## SICEEP, Residential Building W1 (Student Accommodation) (SSDA12) – Response to Department of Planning and Environment Submission

## SICEEP, Residential Building W1 (Student Accommodation) (SSDA12) – Response to City of Sydney Council Submission

SECTIONS

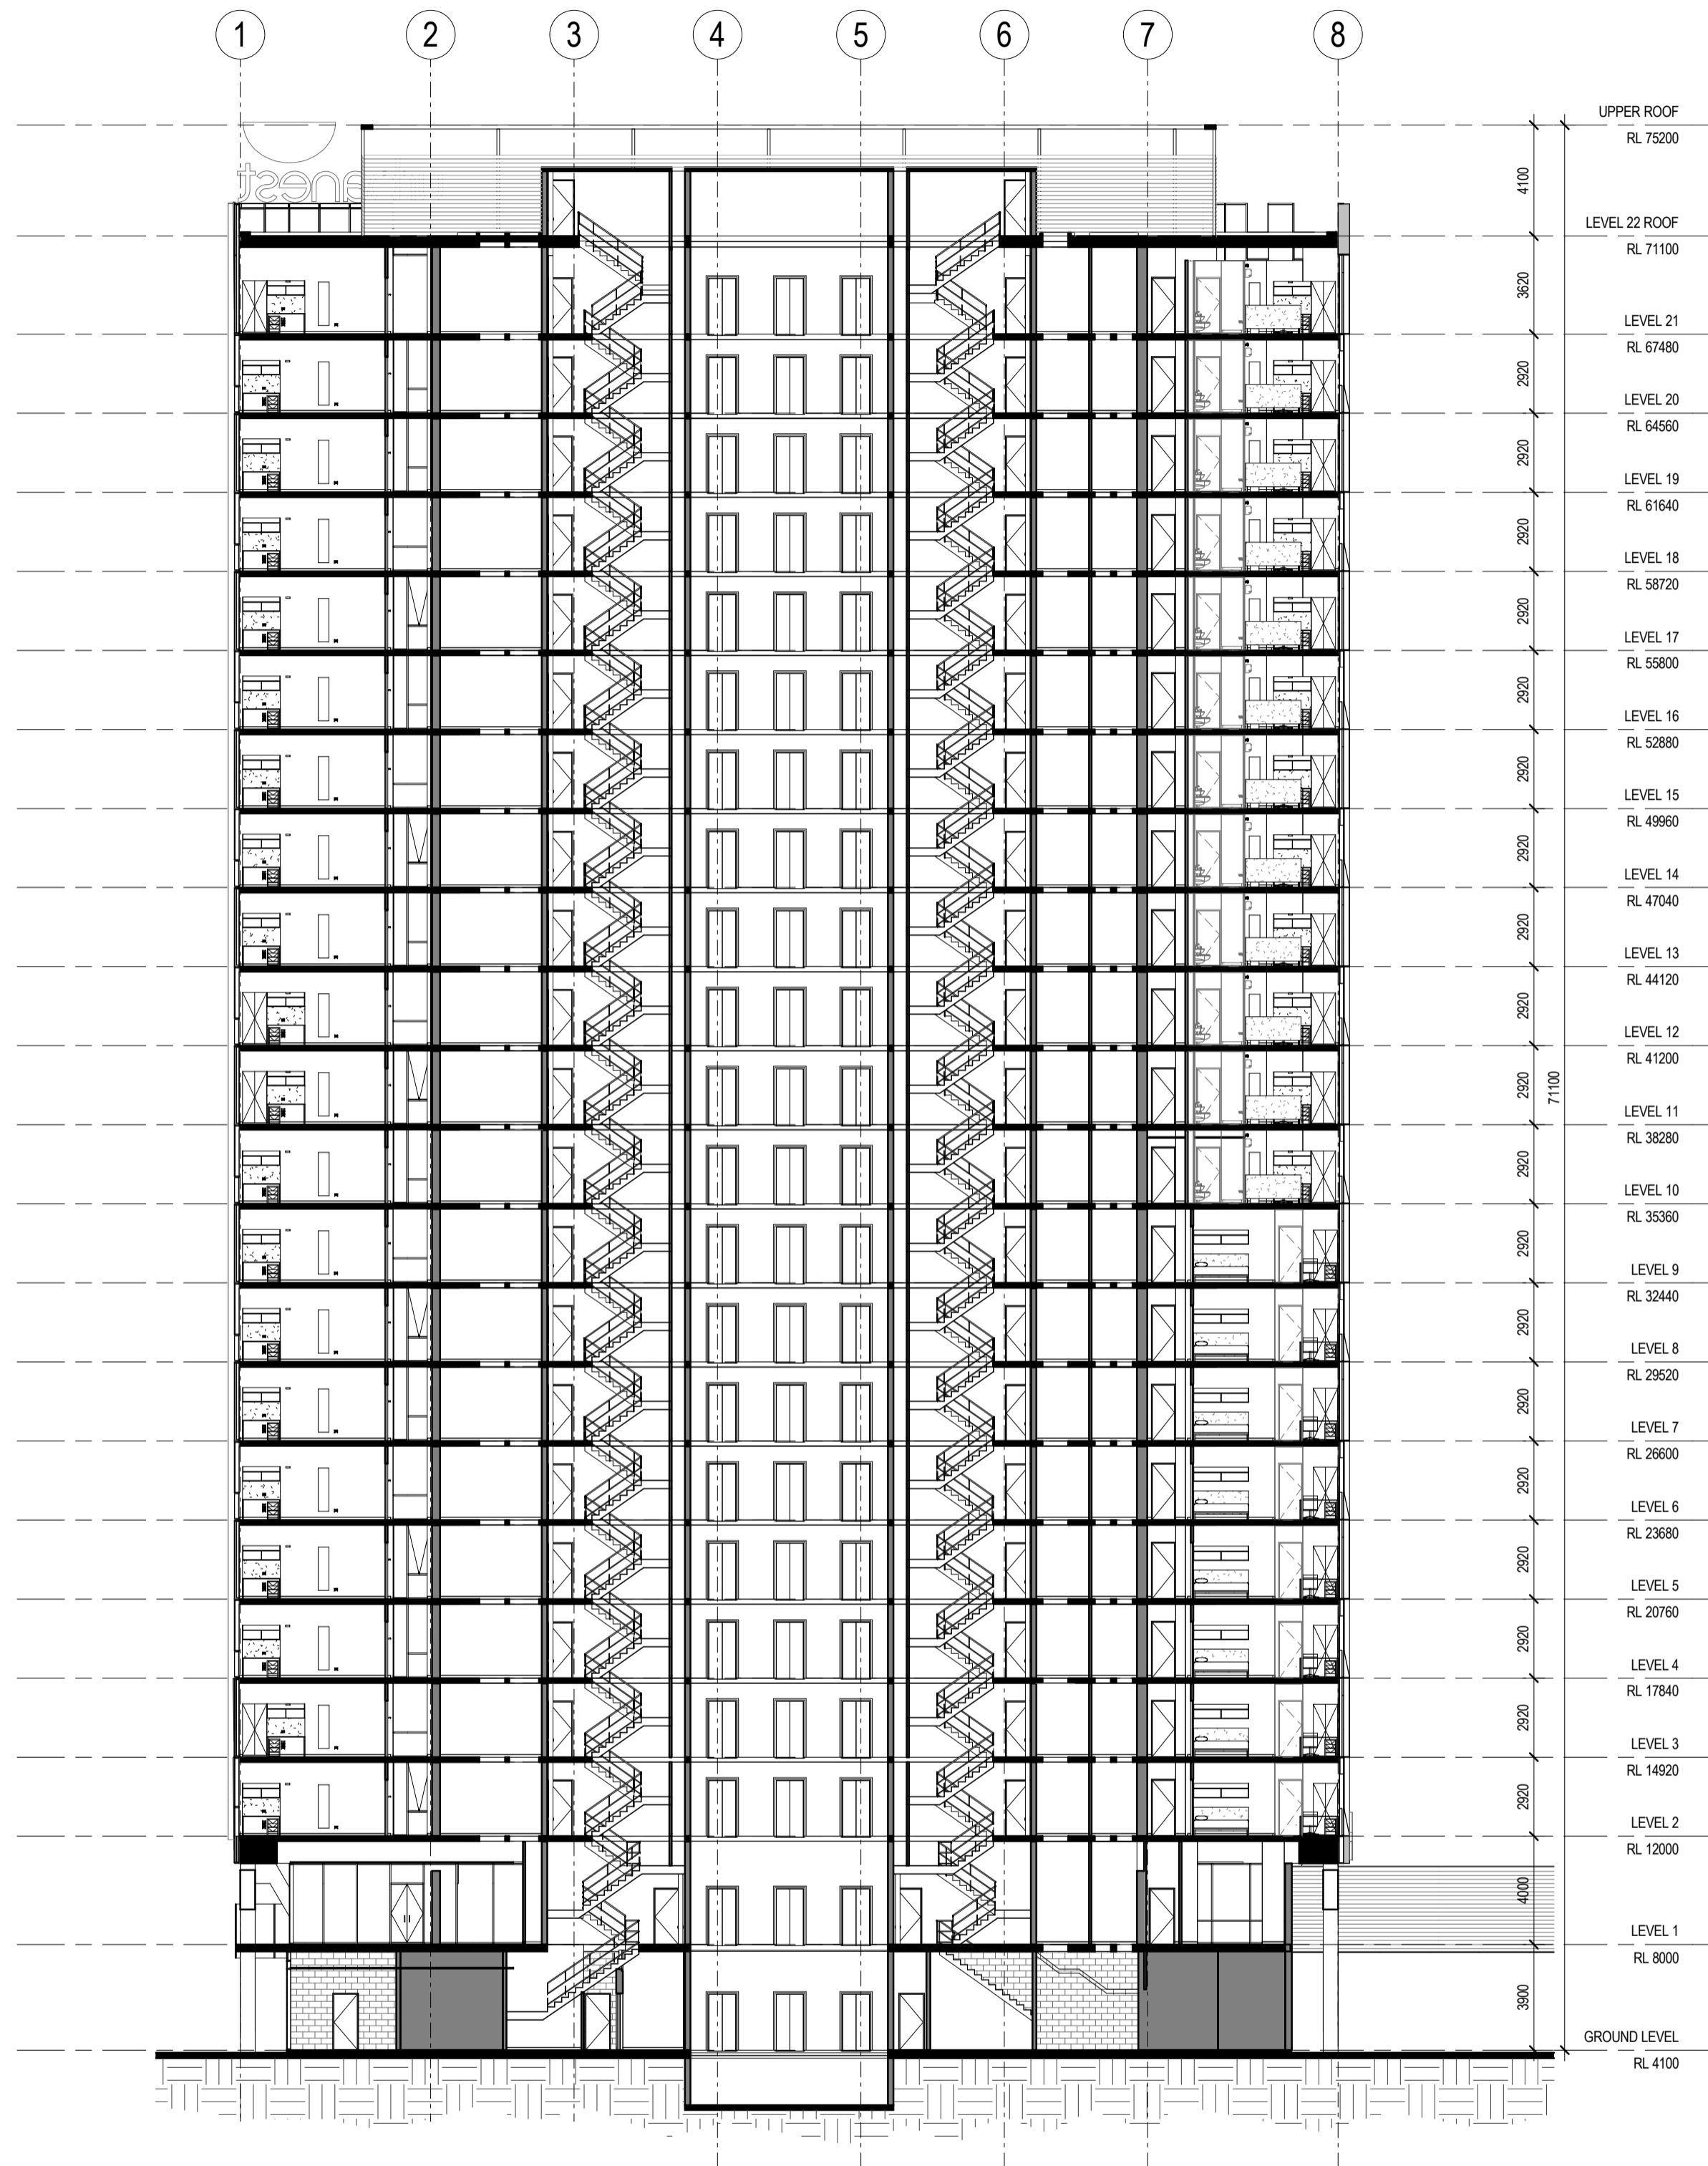
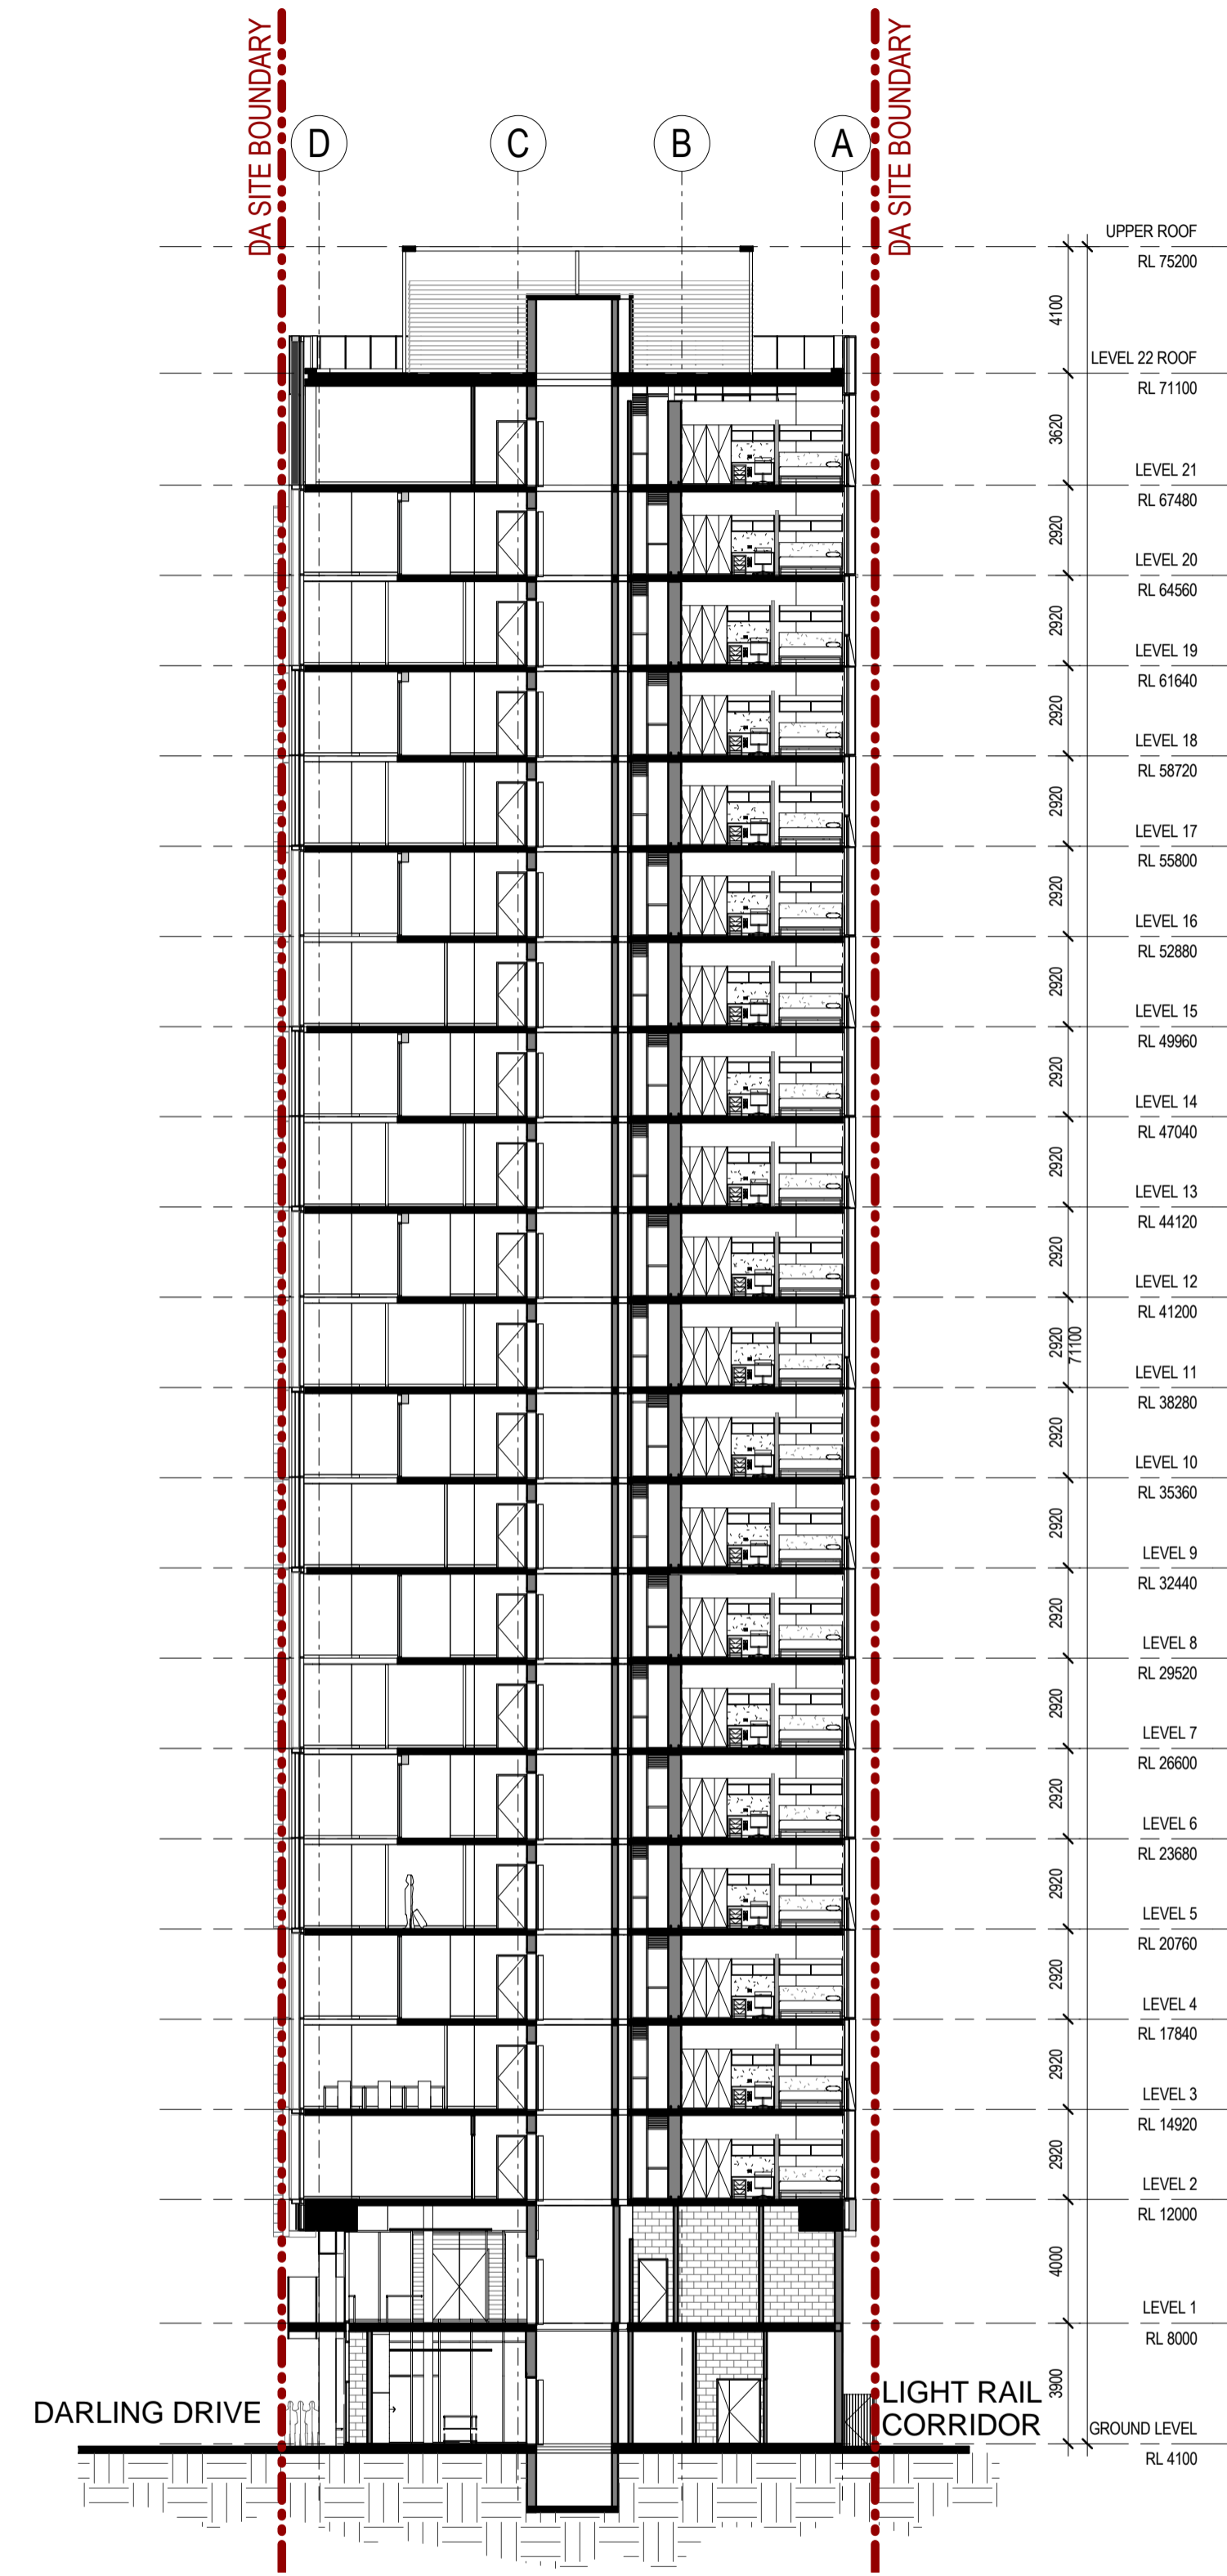
Sections provided show floor-to-floor heights of 2.9m. A floor-to-ceiling height of 2.7m requires a minimum floor to floor height of approximately 3.1m. Given the low ceiling height and lack of natural cross ventilation the amenity of the rooms is considered quite poor, therefore amendments to the ceiling heights should be made.	Building W1 has been designed with a floor to floor height of 2920mm resulting in a general room ceiling height of 2720mm. The ceiling height has been raised a nominal 20mm to ensure the minimum ceiling height of 2700mm required by authority requirements and applicable construction codes (with additional buildability tolerance).
It is noted that communal kitchen facilities are not provided. It is recommended that communal kitchen facilities be provided in accordance with the Sydney DCP 2012 in order to give students the choice of cooking their own food, rather than being solely reliant on the canteen facility.	Buildings W1 and W2 are considered as one integrated facility. If students prefer self-catered accommodation, the adjacent Building W2 facility has ample accommodation. Building W1 is an innovative and pioneering reinvention of catered university dormitory style accommodation. Catering is fundamental to the proposal and the concept will only work with patronage through all inclusive offering.
